An
Bord
Pleanála

Inspector's Report ABP-316027-23

An amendment of Condition 5 of Reg. Ref. FW18A/0079 to increase the annual waste acceptance rate from 270,000 tonnes to 450,000 tonnes per year so as to expand the recycling / recovery capacity and the installation of odour control unit to the rear (east) of Material Recovery Building No. 1. The unit will include an external flue some 18m in height above ground. The increased intake does not require buildings, or extensions to existing buildings. The application relates to development that comprises and is for the purposes of an activity requiring an Industrial Emissions Licence. The facility operates under an IE Licence (No. W0183-01) issued by the Environmental Protection Agency.

Millennium Business Park, Cappagh Road, Dublin 11.

PROPOSED EAST ELEVATION MATERIALS RECOVERY BUILDING 1

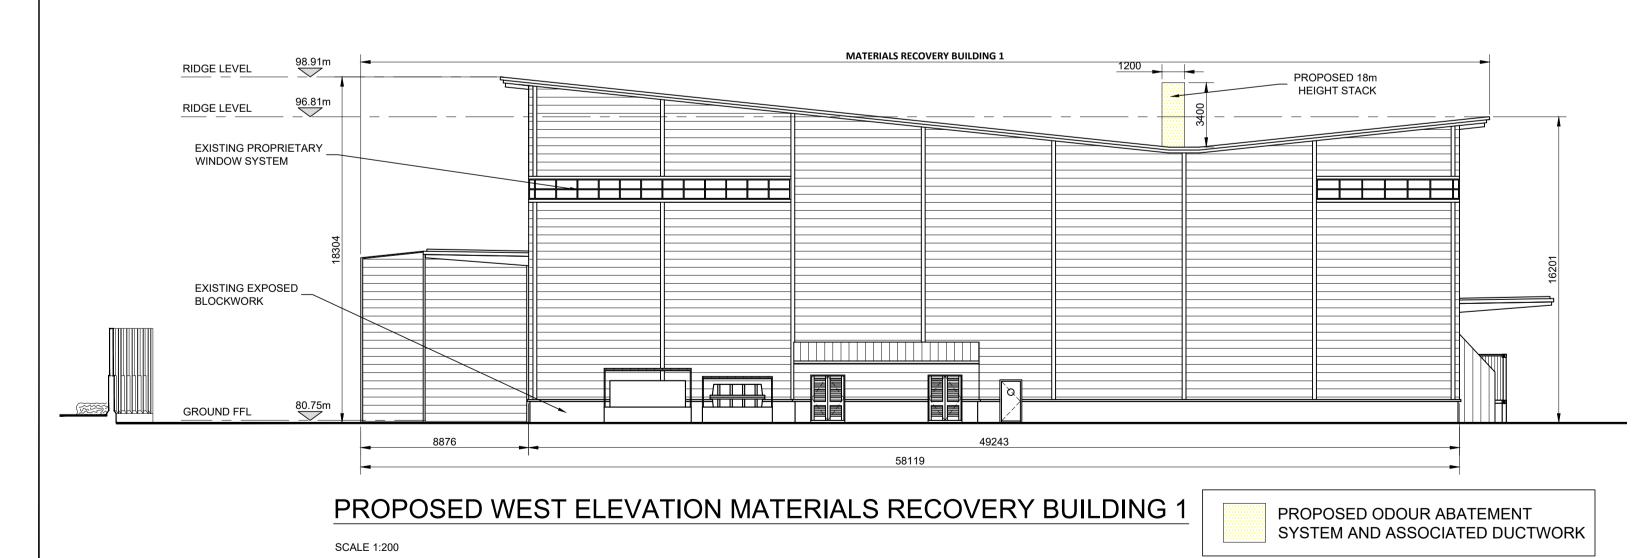
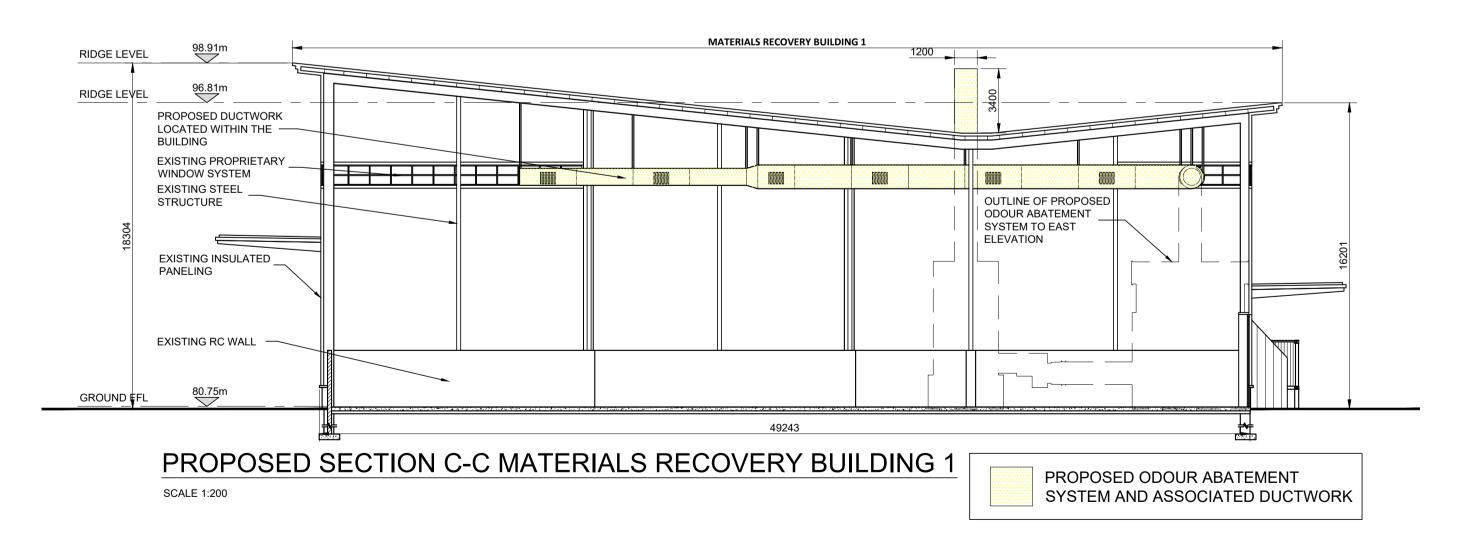
- 3.2. Associated works comprise the installation of an odour control unit to the rear (east) of Material Recovery Building No. 1 which will include an external flue extending to 18m in height above ground level.

- 8. No additional development shall take place above roof parapet level, including air handling equipment, storage tanks, ducts or other external plant, telecommunication aerials, antennas or equipment, unless authorised by a further grant of planning permission.

- (b) No hazardous or liquid waste shall be accepted at the site without a prior grant of planning permission.
- (c) The odour control unit proposed as part of this development shall be constructed and operational prior to the increase in waste tonnage proposed as part of this application being accepted at the site.
